CITY OF PORTLAND

Located At 24 TORREY ST

Job ID: 2011-07-1749-SF

has permission to build a new Single Family Residence.

SHORT RAIN DIVERTER
 FACTORY PRIMED XT19A @
 COMPOSITE EXTERIOR
 PANEL AND BATTENS. SEE
 SECTIONS AND DETAILS FOR
 SIZES

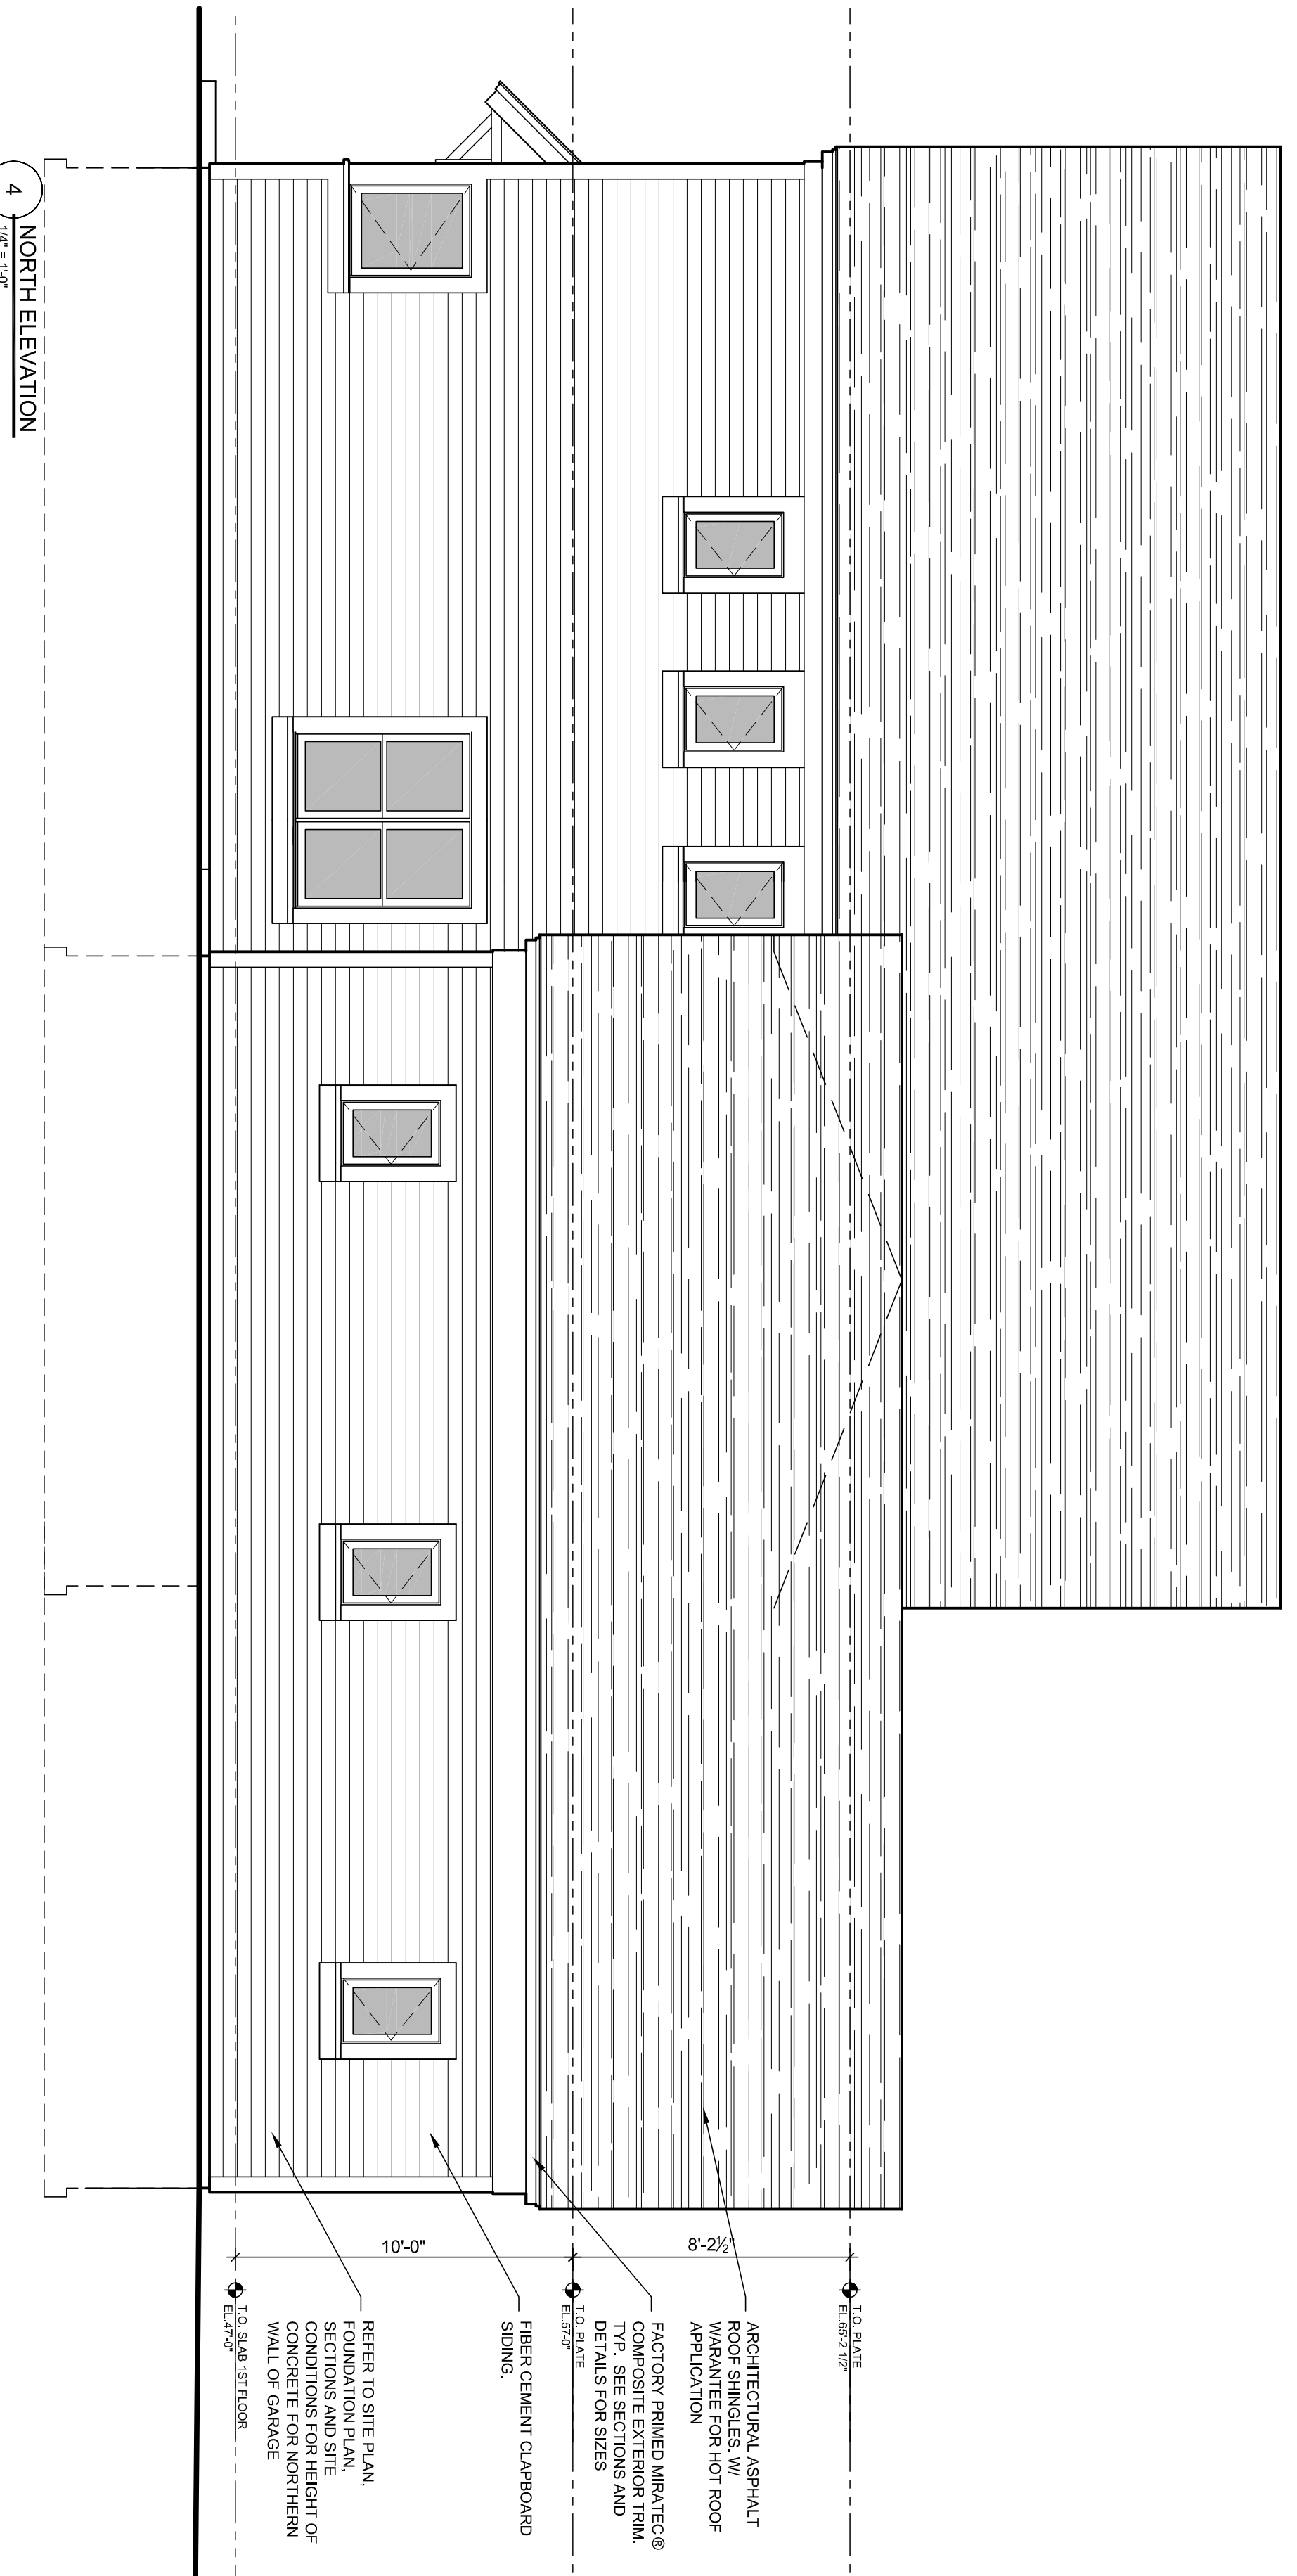
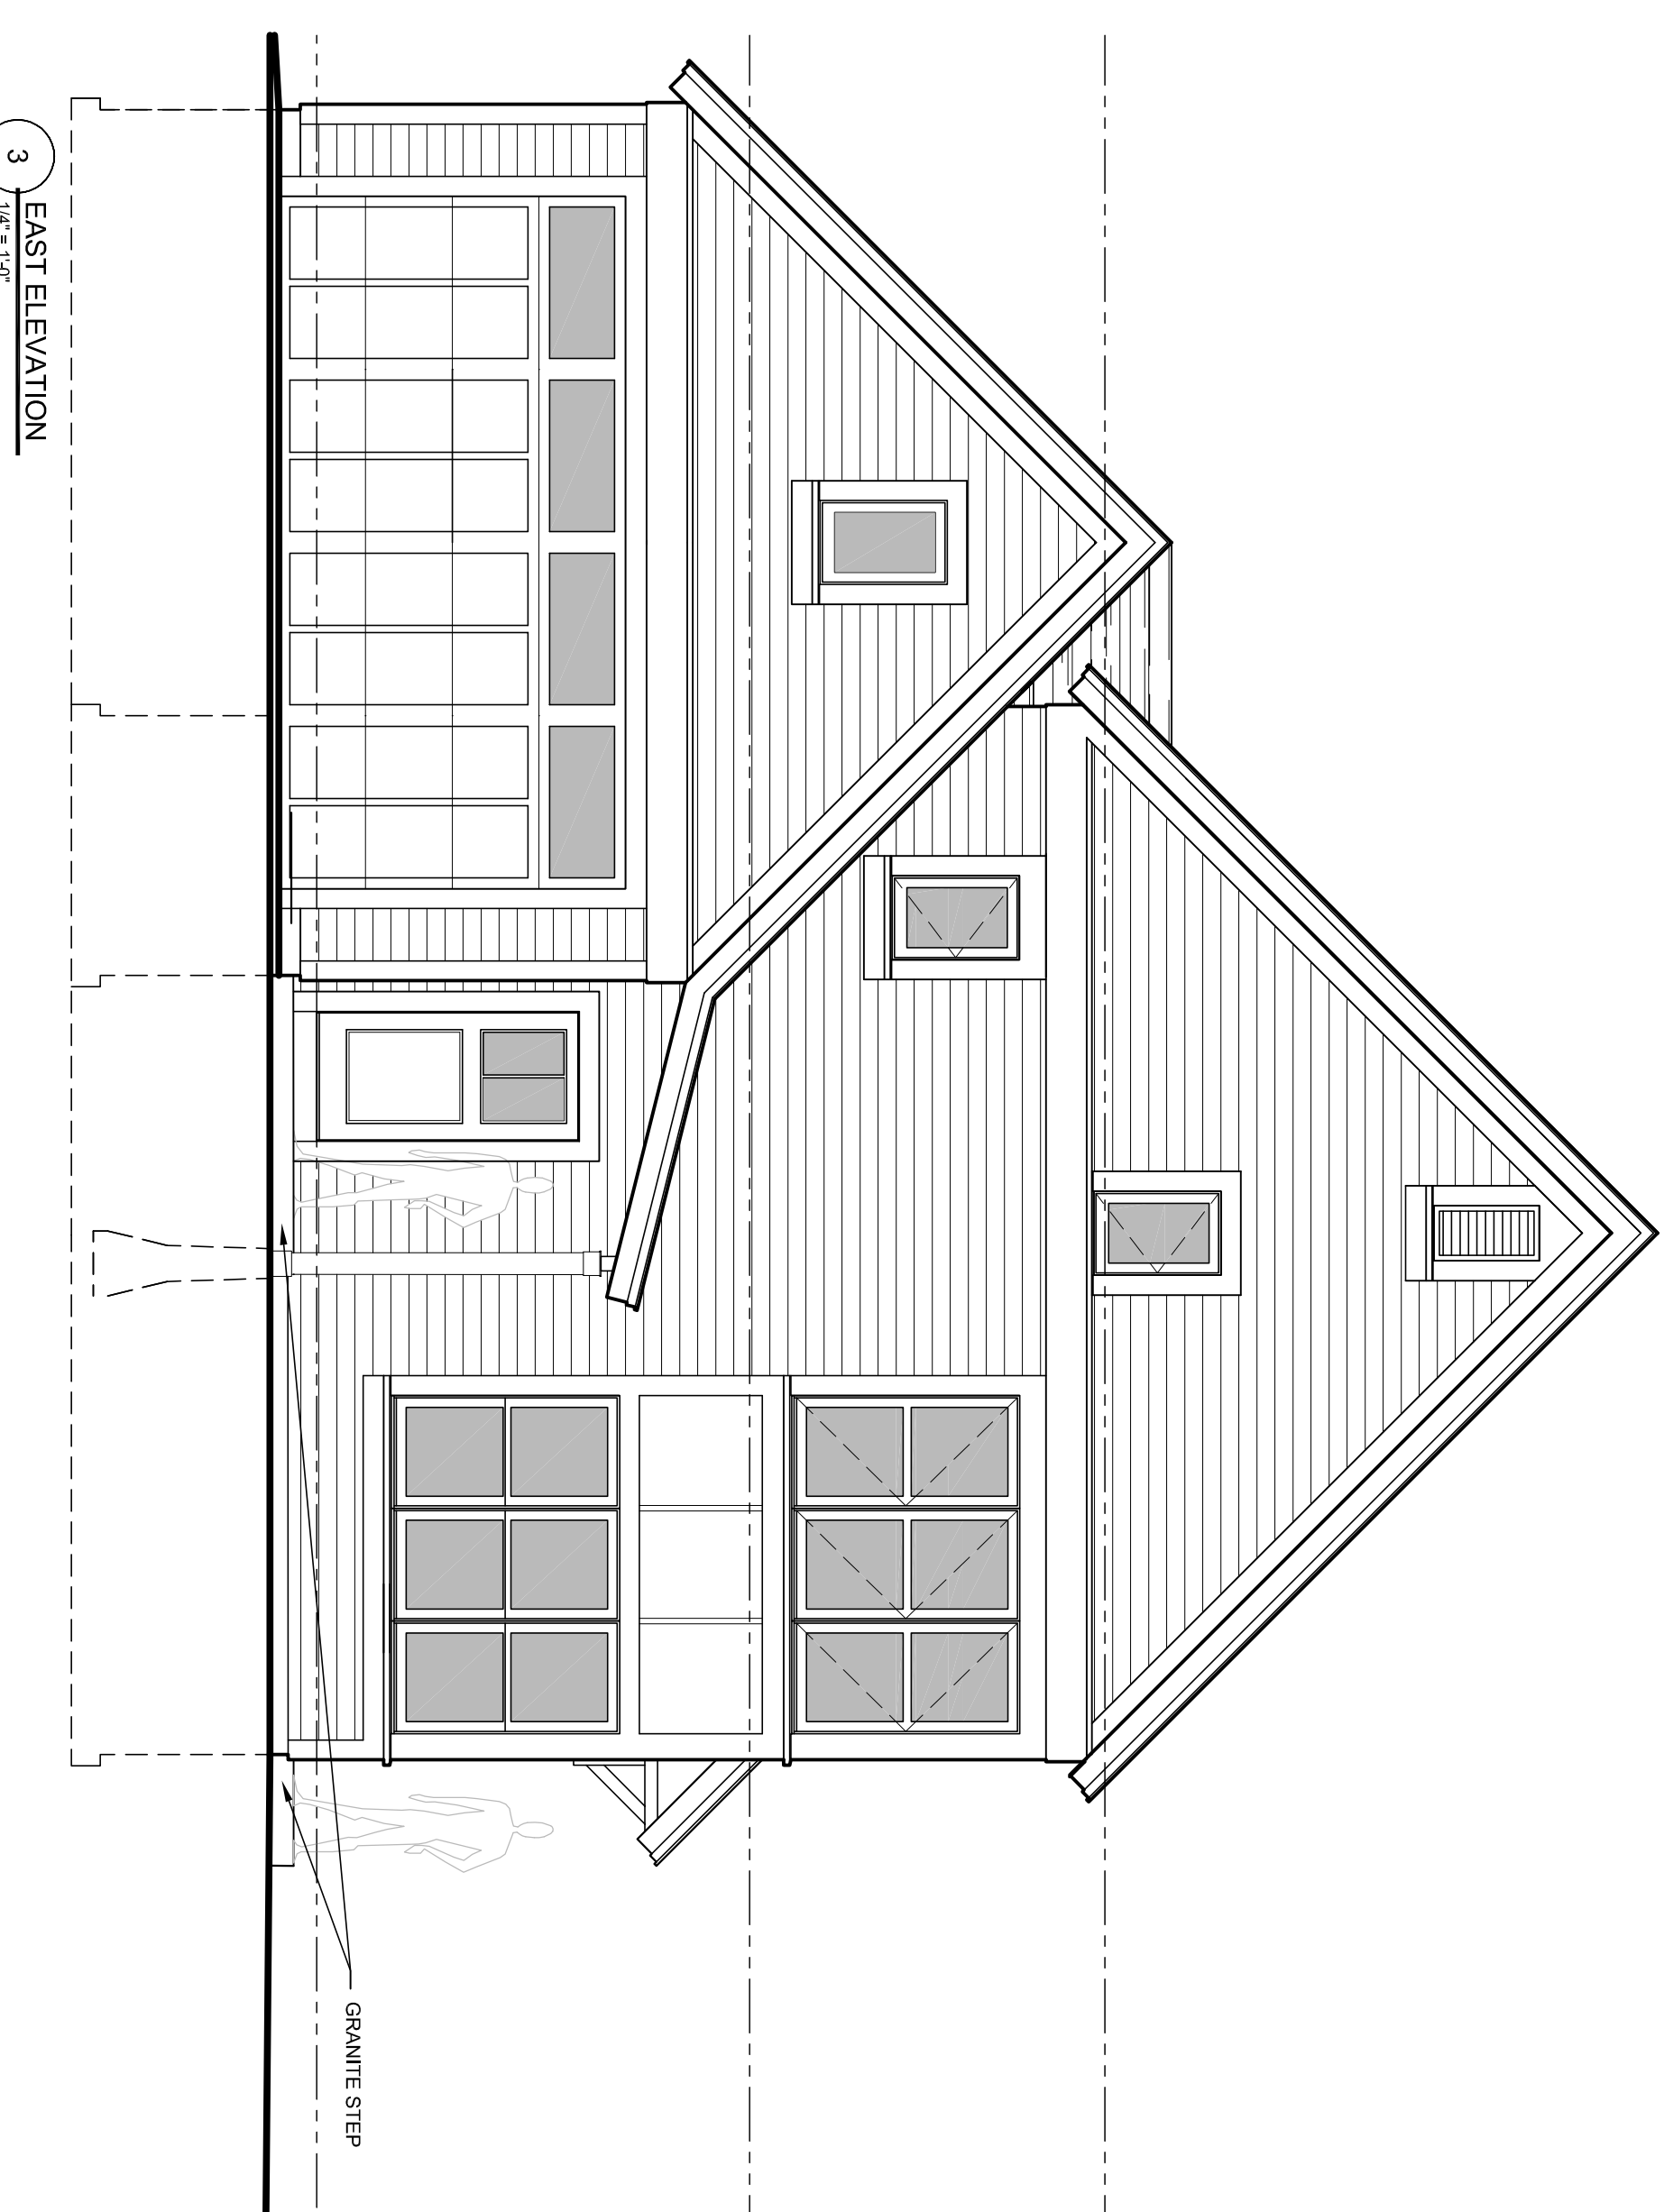
Windows:

- Window sills in locations more than 72 inches from finished grade shall be a minimum of 24 inches above the finished floor of the room, unless a window fall prevention devices is installed in accordance with section R612.3.
- A code compliant emergency escape shall be provided in the bedroom. Window sills in locations more than 72 inches from finished grade shall be a minimum of 24 inches (no higher than 44 inches) above the finished floor of the room.

We will be raising the 2nd floor windows by two inches to ensure their will be >24" above the finished floor. All bedrooms have windows that meet egress requirements.
